OXFORDSHIRE COUNTY COUNCIL'S RESPONSE TO CONSULTATION ON THE FOLLOWING DEVELOPMENT PROPOSAL

Application No: 17/01712/REM

Proposal: Reserved Matters to 15/01012/OUT - Phase 2b (in part) (which comprises a section of the internal spine road) and Phase 3a (in part) which has been split into 2 plots for the purposes of delivery (referred to as plots 2 and 3). This application relates to Plot 2.

Transport

Drwg Title  
**Site Plan as Proposed  
Zone 02**

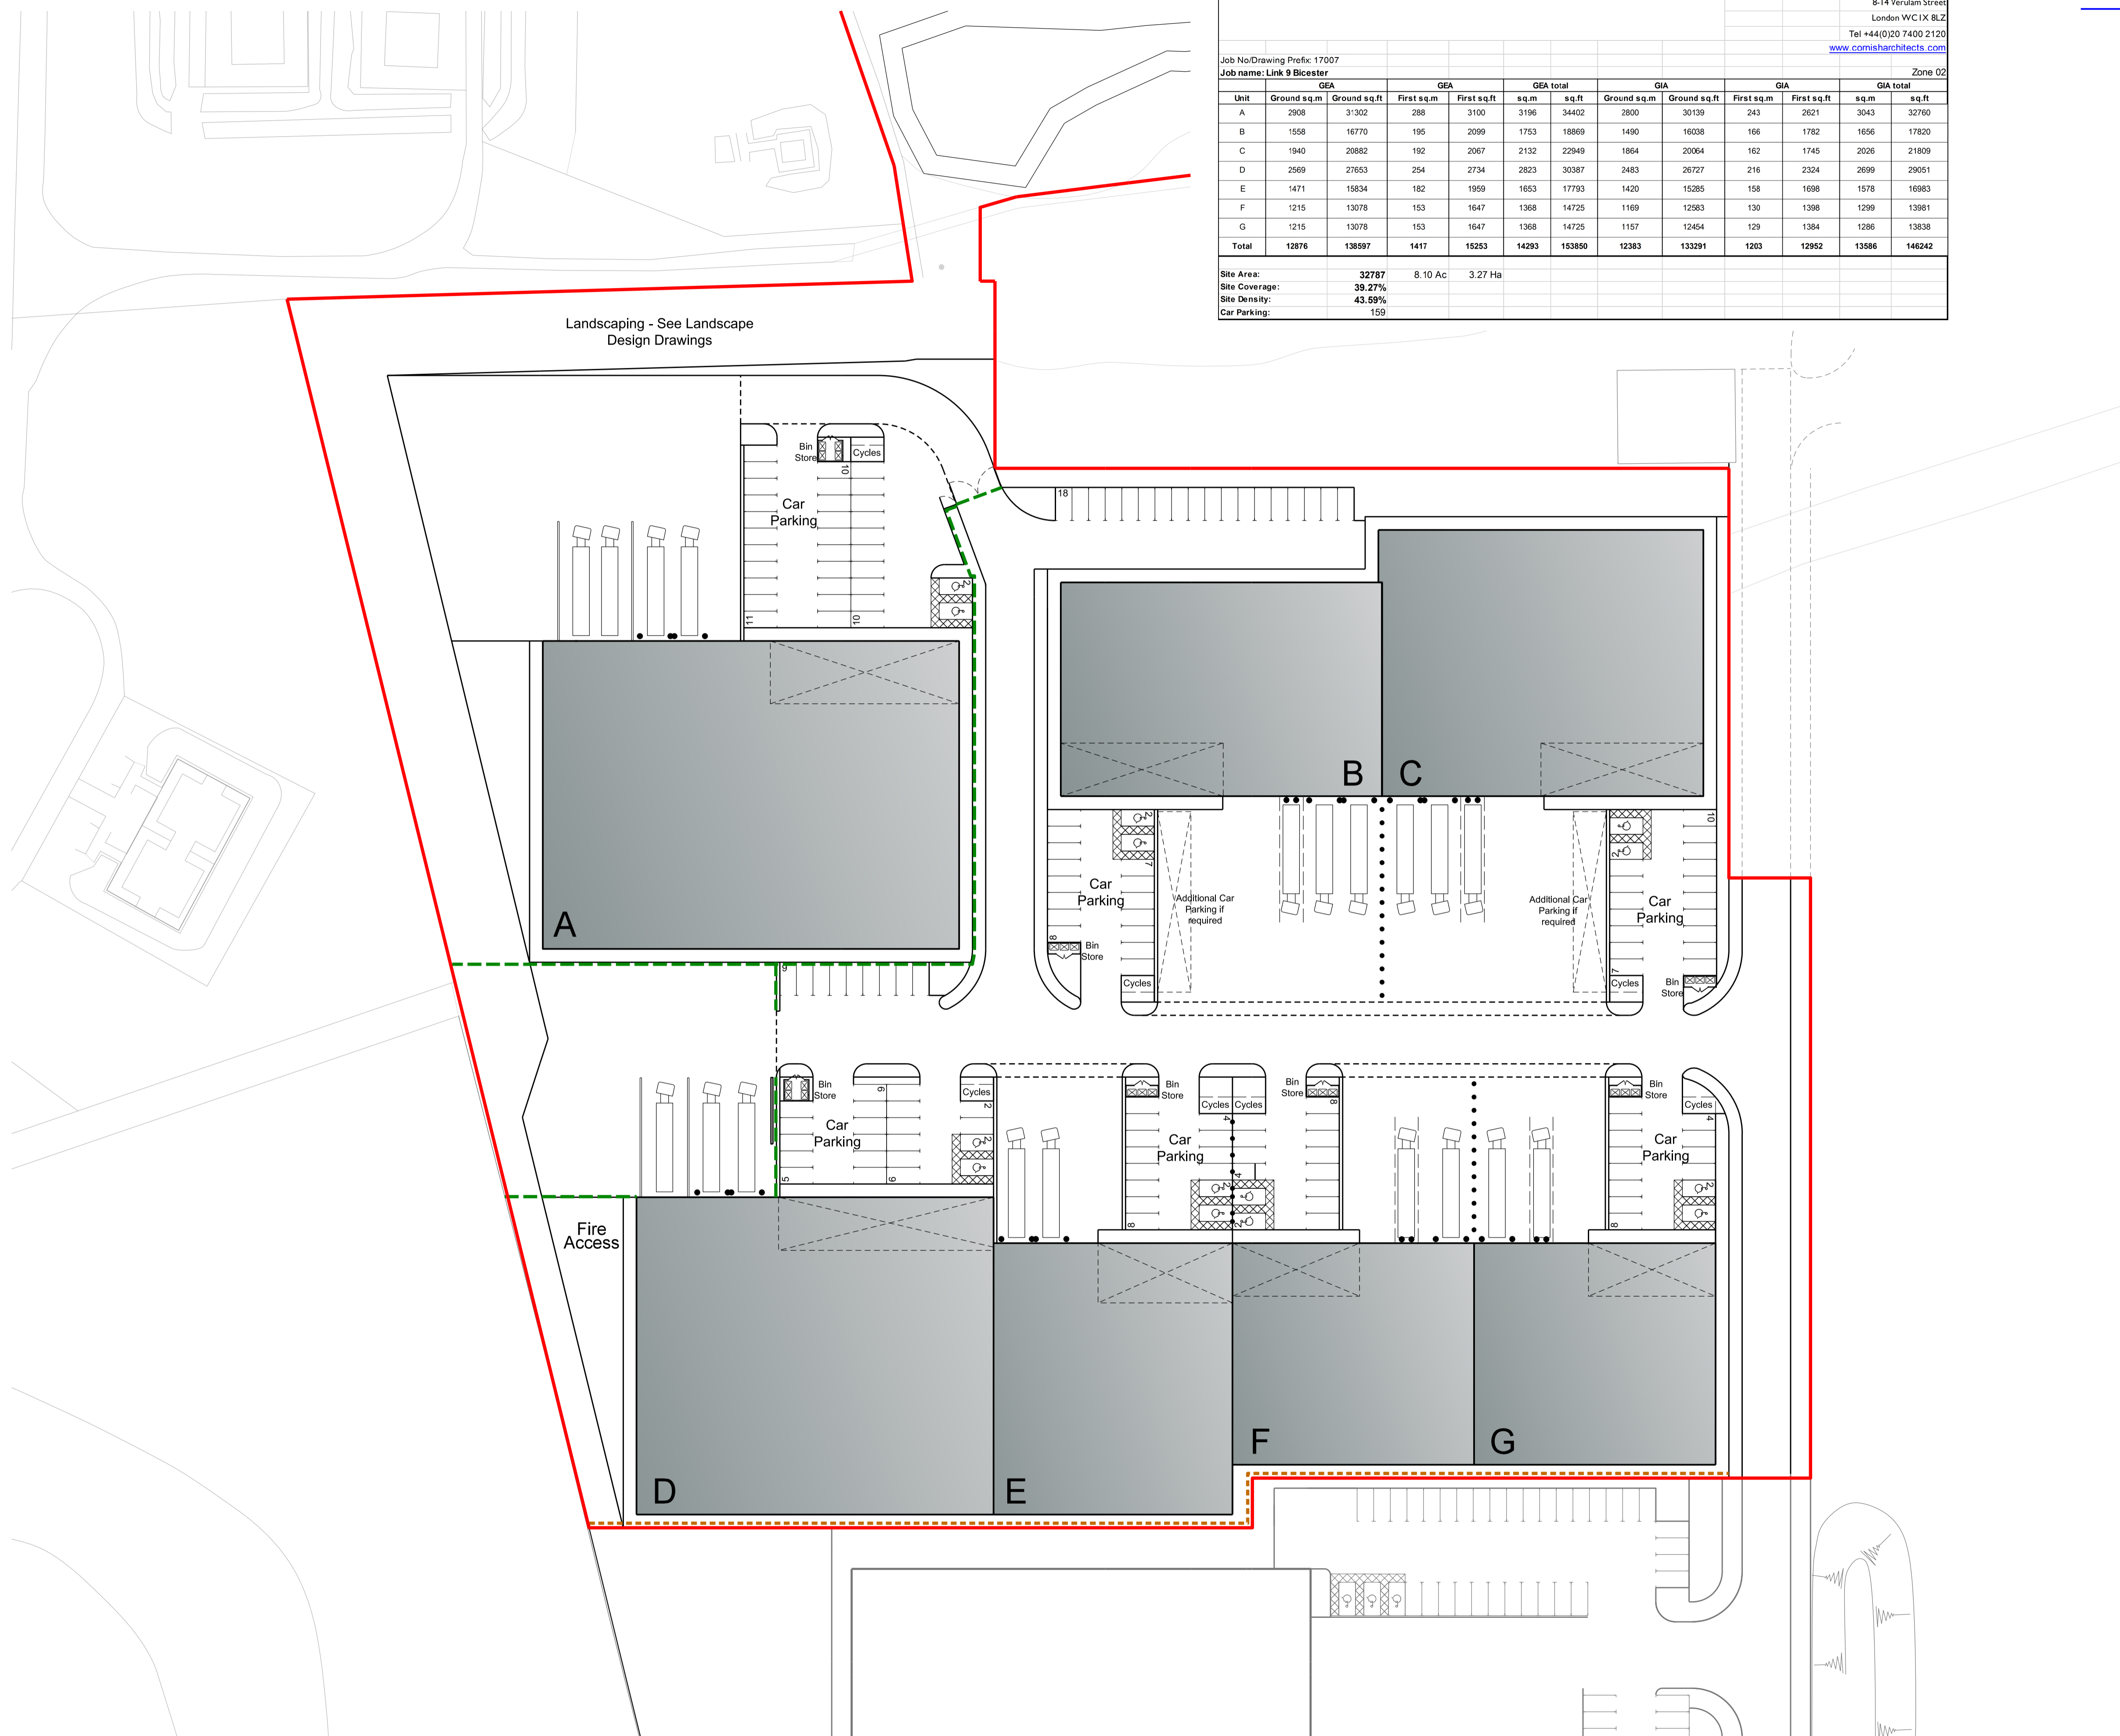
The issues arise, should overspill parked cars inhibit the safe and normal operations of the site and the HGV movements. This will, however, be down to site management. If the additional car parking spaces marked on the site layout plan can be accommodated without affecting the manoeuvring HGVs, then I recommend these be made a permanent fixture.

According to standards in the Inclusive Mobility guidance, disabled parking bays should have a buffer of 1200mm along 3 of their lengths. Currently, the layout shows that disabled spaces adjacent to other spaces or on the ends of rows do not have this buffer provided.

The western footway that continues north from phase 3a, plot 3, narrows to 2m from 3m as it crosses the transition boundary. I am not really sure why this happens and there looks to be room to accommodate a continuation of the 3m footway. As OCC are not adopting the spine road, this is not something we require, as 2m is a satisfactory width for a pedestrian footway. It would be beneficial to have some sort of low level lighting that marks this indentation.

Informal crossing points between each section of footway should have dropped kerbs and tactile surfacing, to accommodate all pedestrian users. This sort of detail can be submitted by way of condition.

JOB TITLE: Skirmingditch Lane, Plot 2 CLIENT: Albion Land
 DRAWING TITLE: HGV Tracking
 SCALE: 1:500 DRAWN BY: BP DATE: Oct 2017 DRAWING NO: 15230-19 REVISION: A

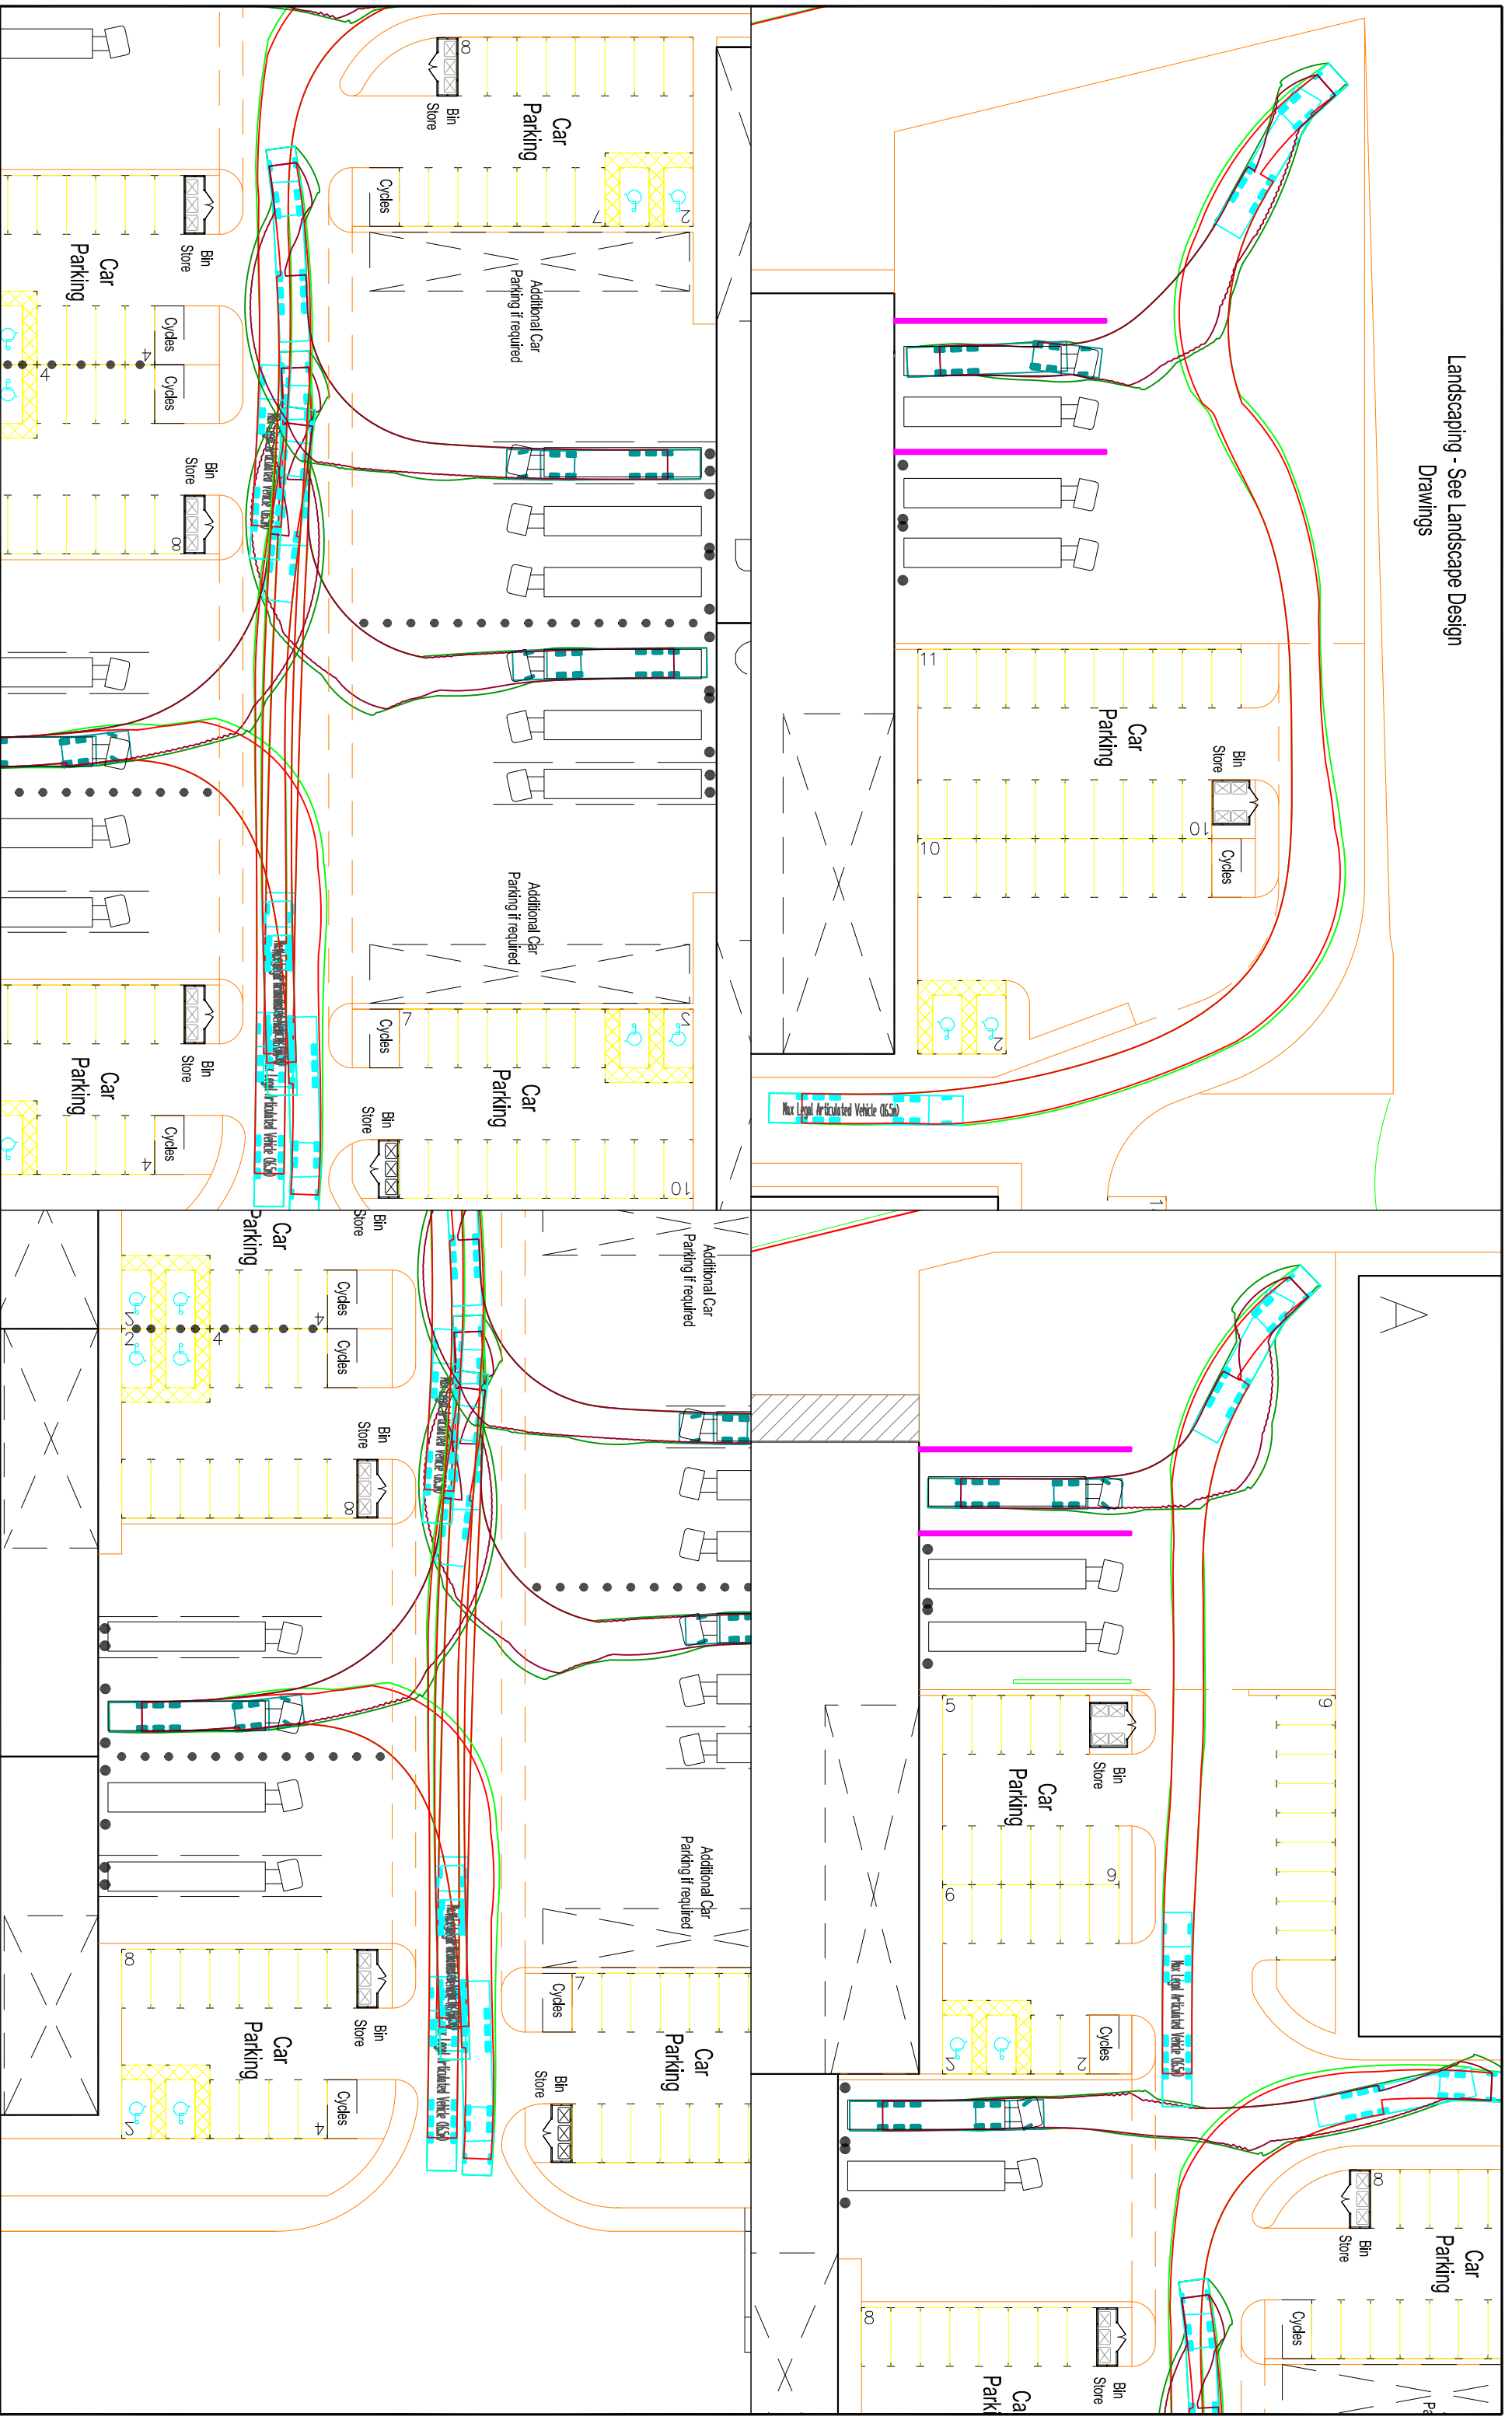
The applicant must submit vehicle tracking of the largest HGVs using the site, to ensure the safe manoeuvring of these vehicles that allows them to enter, unload and leave the site in a forward gear. The tracking should show car parking spaces with cars parked in them.

04 TYPICAL CYCLE SHELTER
2017 Broxap Apollo Grey RAL 7016

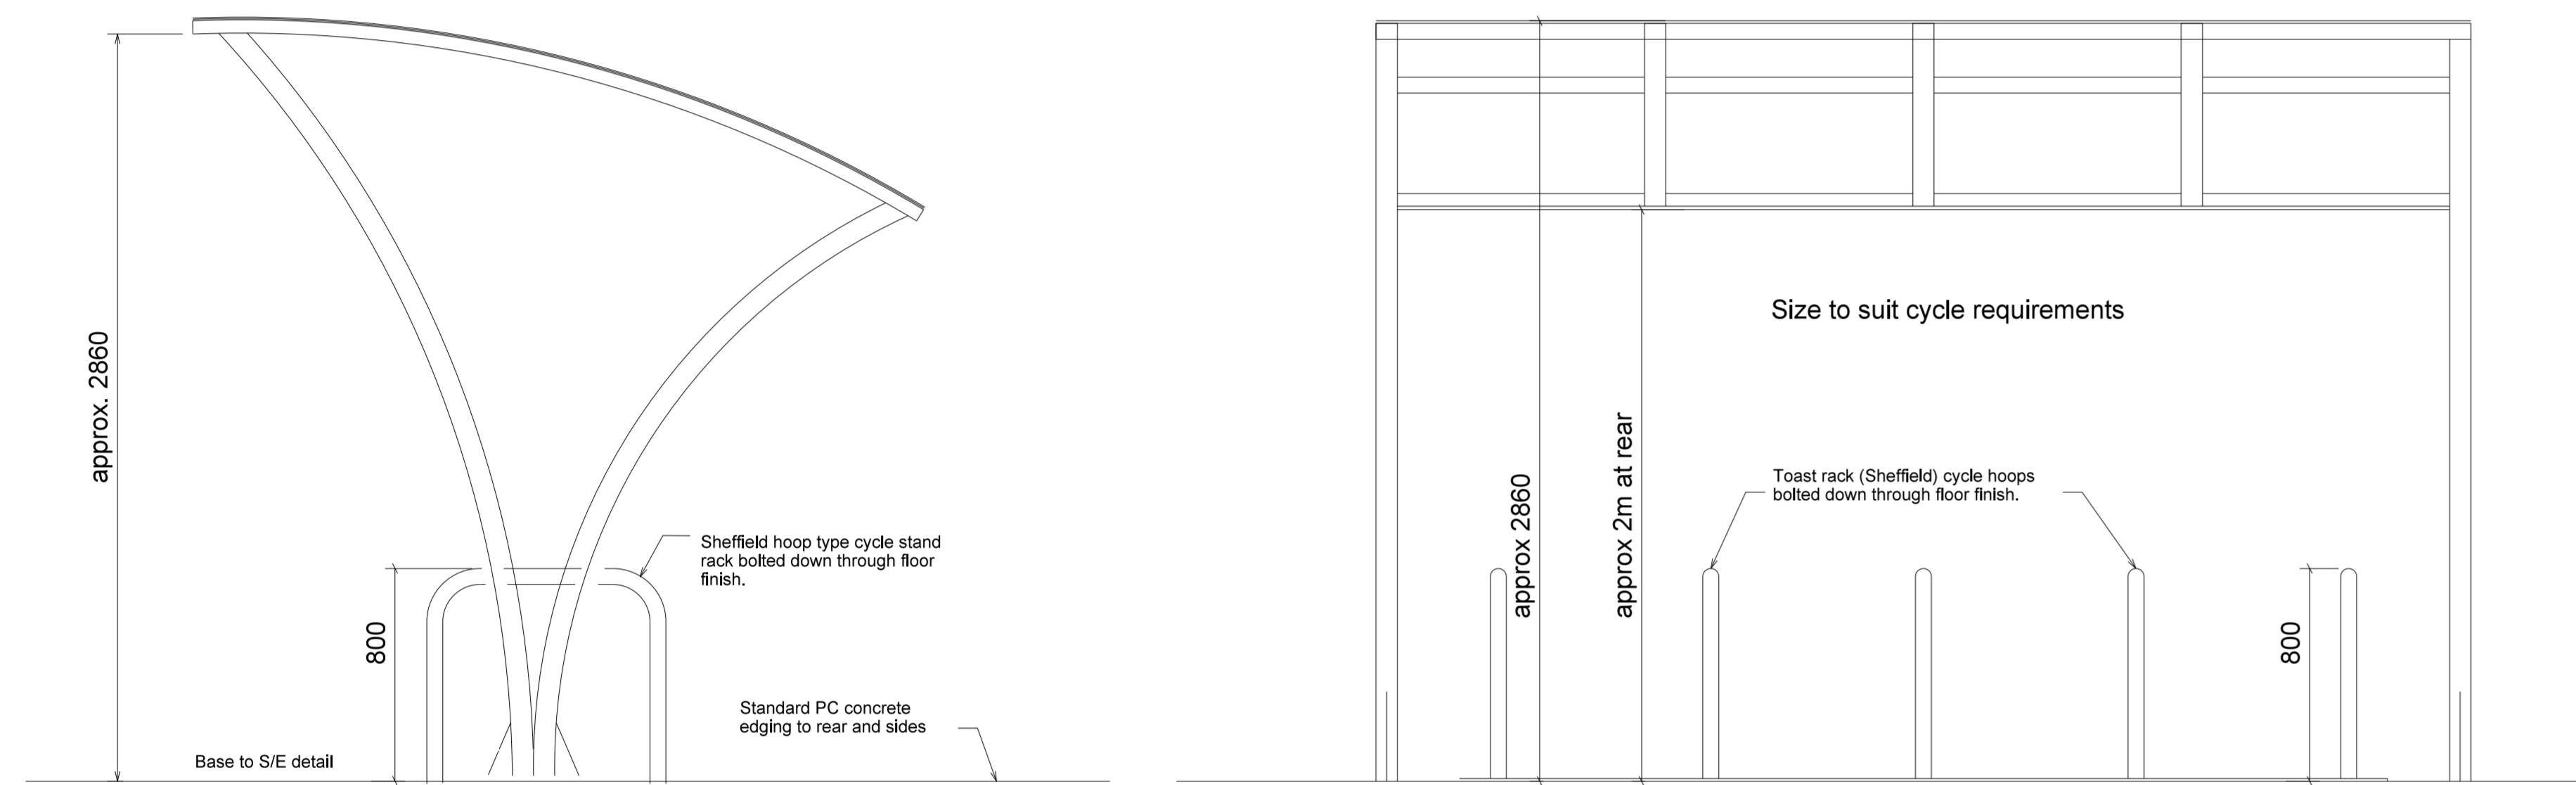
Cycle parking is to be provided at a ratio of 5 Sheffield Stands (10 spaces) per unit, which totals 35 across the site. We require details to be submitted, showing the details of these cycle stores. OCC want to see the stands at least 900mm apart and covered, thus encouraging staff to leave them there all day throughout the year.
